DELEGATED DECISION TO DETERMINE PLANNING APPLICATIONS

Reference No: 2020/62/94164/E

Site Address: 8, Millers Croft, Birstall, Batley, WF17 0RN

Description: Erection of front and rear dormers

PROPOSED FRONT ELEVATION.
SCALE 1:100.

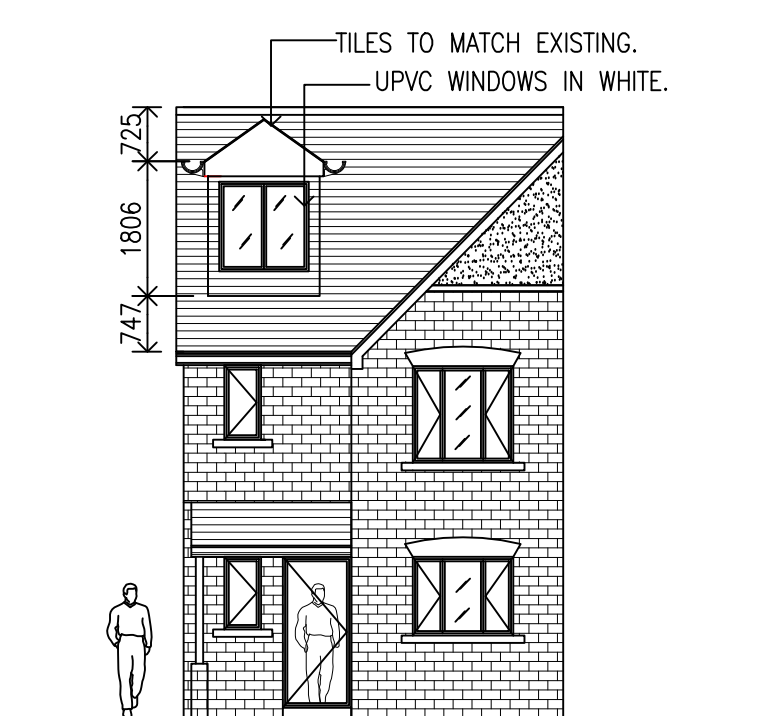
The facing and roofing materials are the same as approved. No additional impact on visual amenity and the local street-scene would arise from this development, compared with the approved scheme. The design of the front dormer has now reverted to a dual-pitched roof, which looks in-keeping with the surrounding buildings in the vicinity of the site on Millers Croft. Whilst there are minor changes to the fenestration detailing of the rear dormer, they are not found to affect the overall appearance of the house to any significant extent. Overall, therefore, this development is acceptable in design terms.

PROPOSED REAR ELEVATION.
SCALE 1:100.

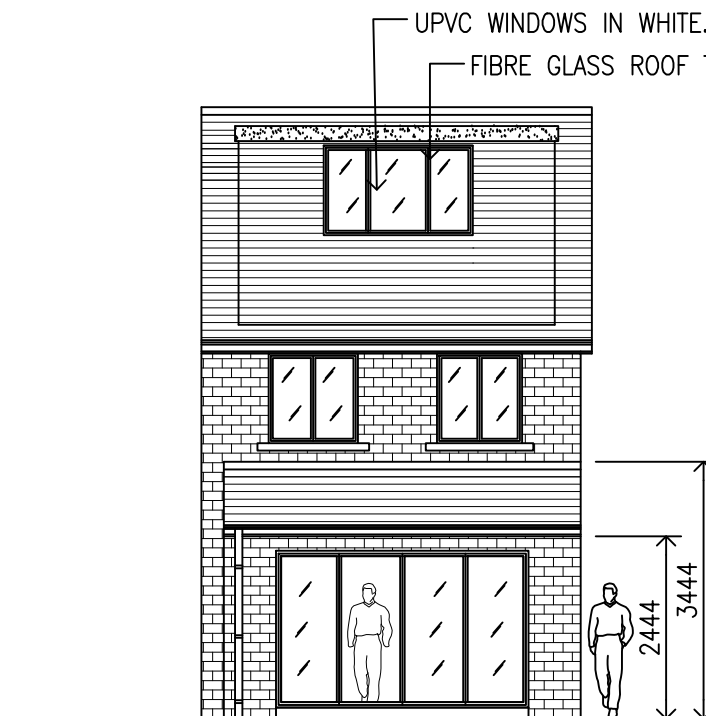
The proposed dormers are positioned in the same way as approved, albeit being slightly larger than approved in 2017. As such, they are considered not to have a greater impact on the privacy of the neighbours than the approved dormers. The difference in land levels and the separation distance with the surrounding development could alleviate the privacy concerns raised in the written representation. No additional overshadowing and overbearing impacts are anticipated for the development under consideration.
